Application Ref:	3/2026/0360			 Ribble Valley Borough Council www.ribblevalley.gov.uk
Date Inspected:	19/05/2026	Site Notice:	19/05/2026	
Officer:	MC			
DELEGATED ITEM FILE REPORT:				APPROVAL

Development Description:	Listed Building Consent for proposed repairs to chimney.
Site Address/Location:	Lower Dutton Cottage, Gallows Lane, Ribchester, PR3 3XX

Drawing Title
Chimney Details

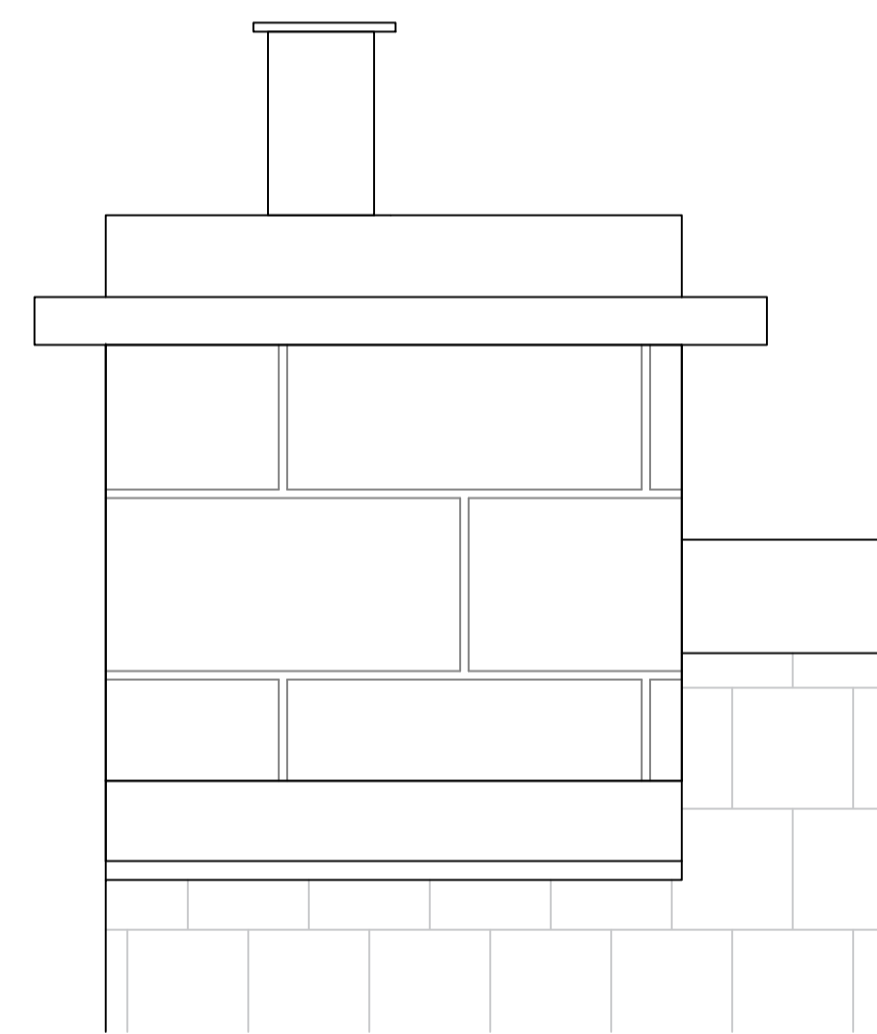
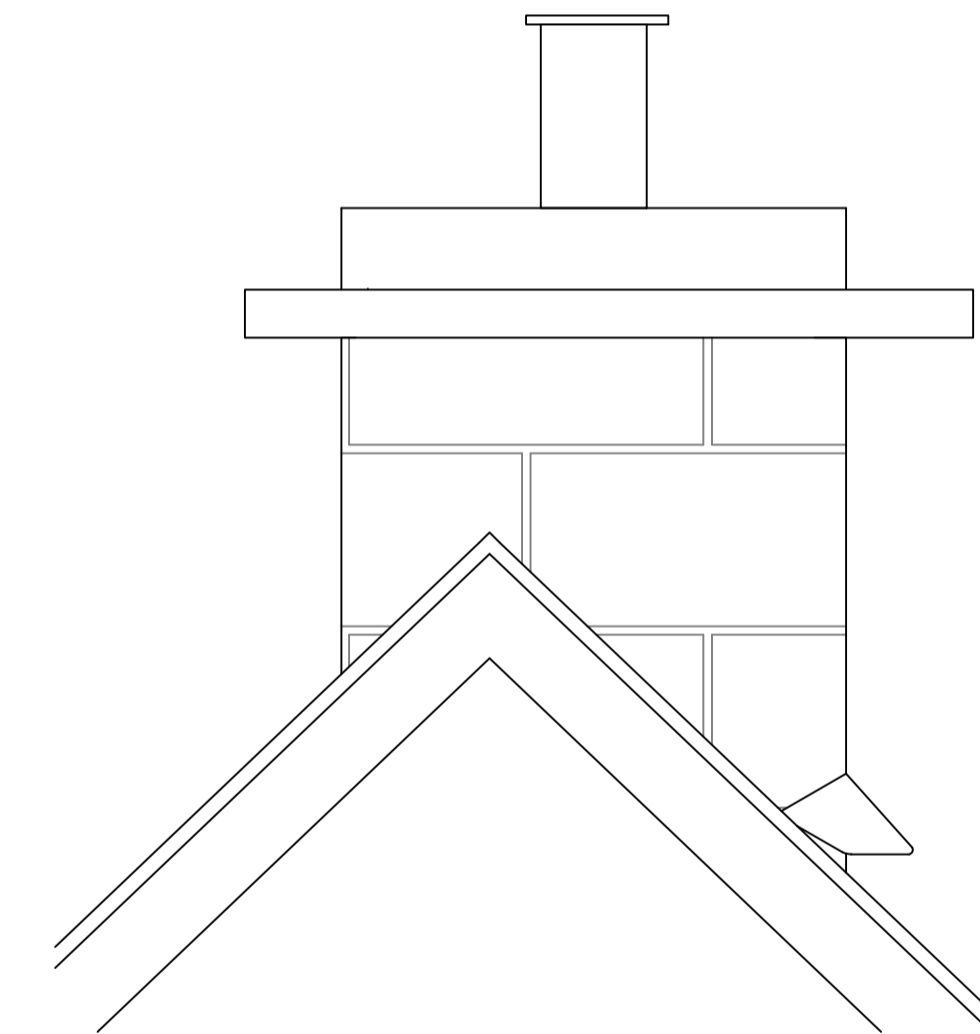
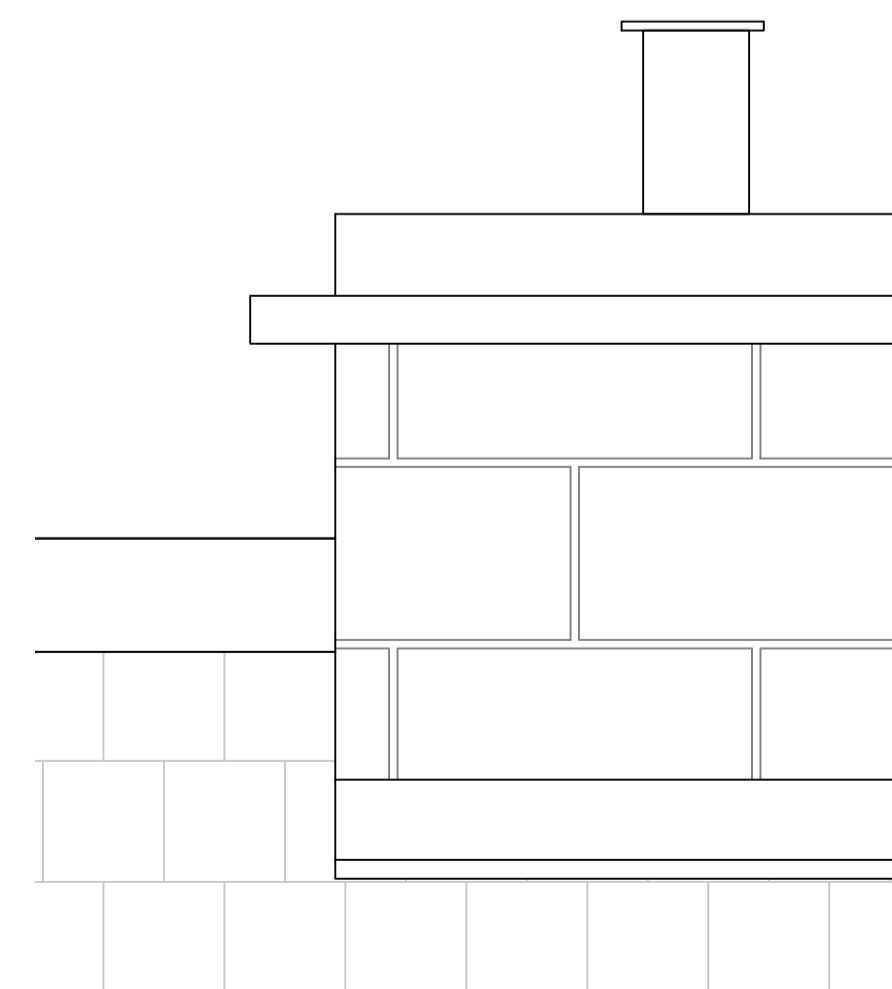
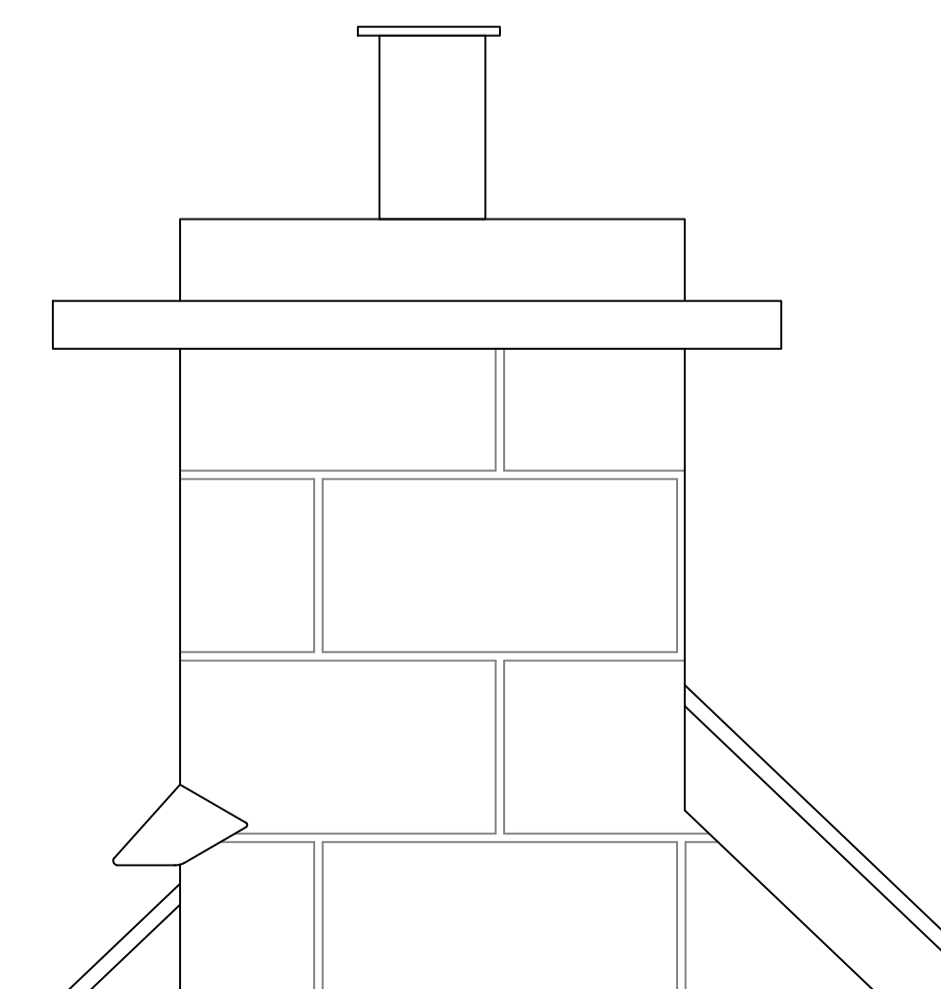
The proposal is for the repair of the external fabric of the west gable chimney. The supporting statement outlines that the sandstone is “severely degraded / perished” to the chimney which was impacted by storm damage earlier this year and historically by moisture entrapment as a result of past repairs in modern

From review of the photographs the cracking, missing sections of stone to the stack and weathering details are evident, together with previous repairs in cement mortars / renders, the Heritage and Conservation Officer agrees are likely to be contributing to the deterioration of the stonework. They consider that the proposed method of repair and materials set out on in Section 5.0 of the Design, Access and Heritage Statement is acceptable, though they recommend that the chimney is not limewashed (a possibility of using a limewash is noted on page 4) since the it does not appear to have been previously limewashed – though further onsite work may find otherwise.

With regard to the proposed lime mortar mix, they consider that an NHL3.5 for the stack and NHL5.0 for the flaunching would be acceptable and would be a betterment to the existing cement mortar. The proposed pointing styles is considered acceptable, though they recommend that in the work should be protected from the elements (at least 3 weeks with a double layer of damp hessian).

They consider that the replacement of the chimney pot would be acceptable only where the existing pot is beyond repair, in which case, replacement with a pot of the same profile and dimensions would be acceptable. The proposed Code 5 leadwork is considered to be acceptable with use of traditional methods of lead wedges and pointing in lime mortar. In addition, they recommend use of a patination oil on completion to avoid carbonate staining to the slates. With regard to the replacement of any stone sections and the chimney pot, the approach proposed in the supporting document is one of *minimum intervention* replacing only the material, with matching materials and profiles, which is deteriorate beyond being capable of re-use. They consider that this approach is represents good conservation practice, though are aware that the potential to re-use the chimney pot and individual sections of stone will be able to be determined only when the render / existing flaunching and mortar is removed.

The photographs illustrate the perished extents of the stone and they consider that replacement of the perished sections in sandstone to match the existing, with matching profiles is acceptable. Since it is unknown if the chimney pot requires to be replaced, they recommend that details of the condition of the existing pot and proposed new pot, prior to fixing should be confirmed, which could be secured via a suitably worded planning condition.

Subject to a suitably worded Condition securing the replacement of the existing chimney pot only where its condition is beyond re-use, and details of the lime rendering being secured, they consider that the proposal would meet the statutory test 'to preserve', causing no harm to the significance of the listed building.
